# CITY OF ALBUQUERQUE

December 19, 2014

**Re: Glenrio Apartments Phase I  
Tracts 223-4 Airport Unit  
Request for 180 day Temporary C.O. - Accepted  
Engineer's Stamp dated: 05-5-14 (J10D043)  
Certification dated: 12-16-14**

PHASED GRADING
 PLAN

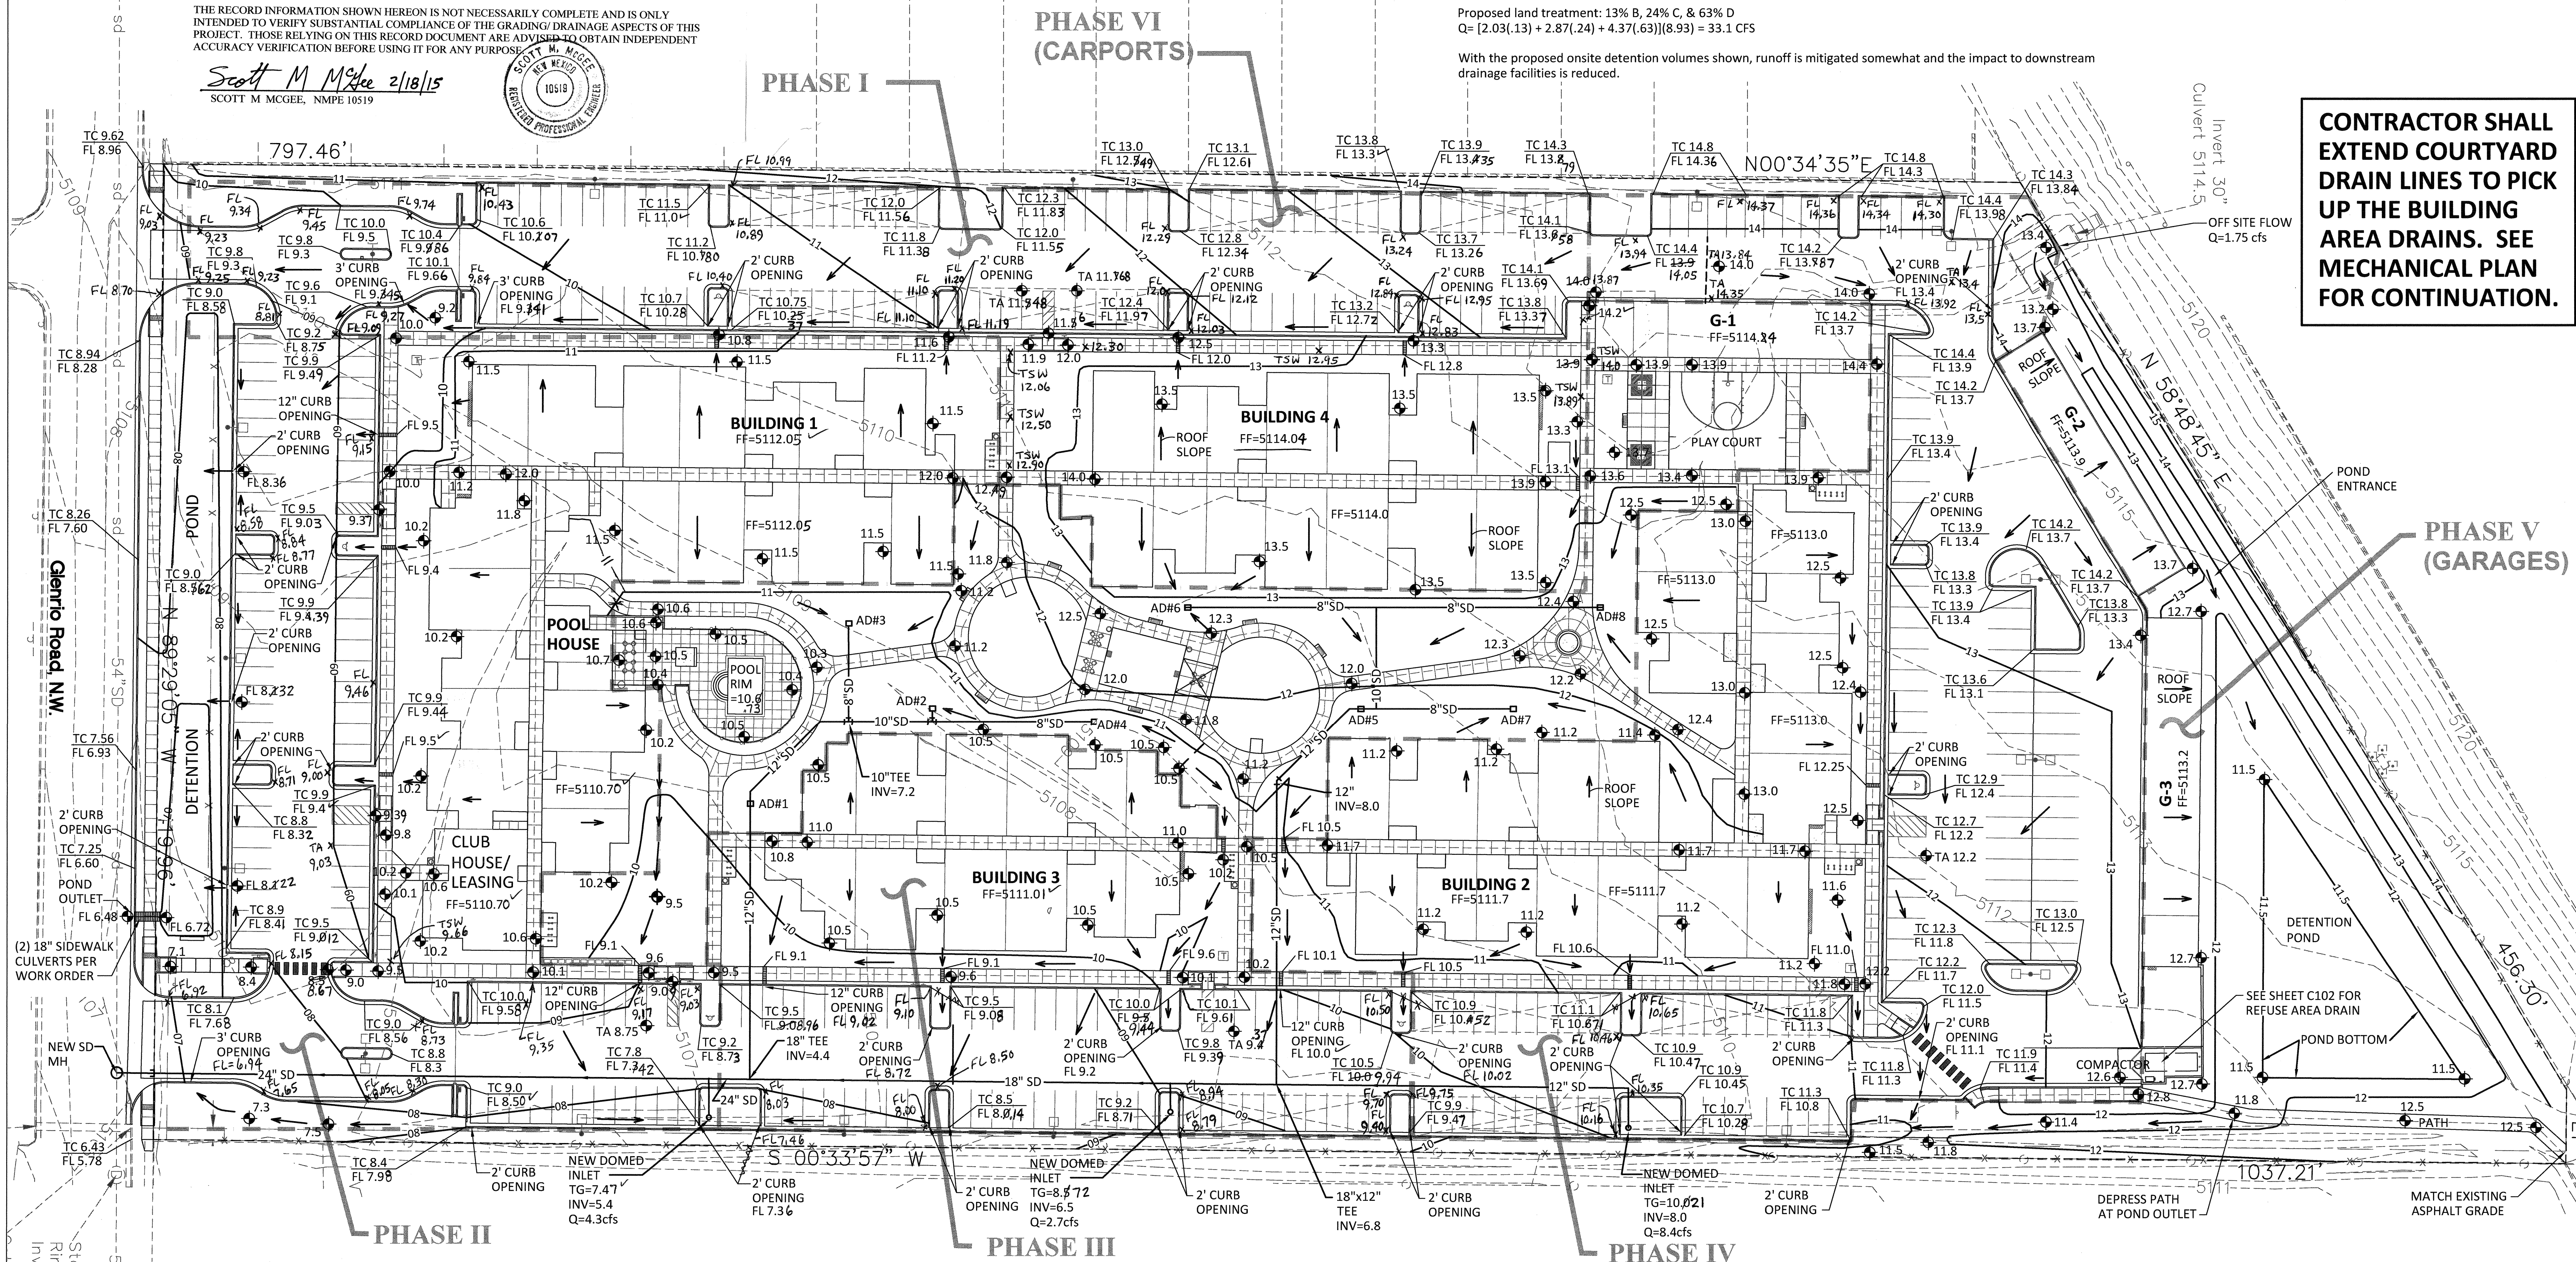
The following comments are to be addressed when submitting the next certification.

- The plan submitted must match what is built including spot elevations in and around all ponds, sidewalk culverts, curb & gutters or flow lines. It is preferable for the original spot to be lined out with the new spot written below the original or next to it.
- If some part of the plan was not erected or built, exceptions in the Drainage Certification should be mentioned.
- Curb cuts were missing by two of the sidewalk culverts. Curb cuts by the other culverts were 4" in width.
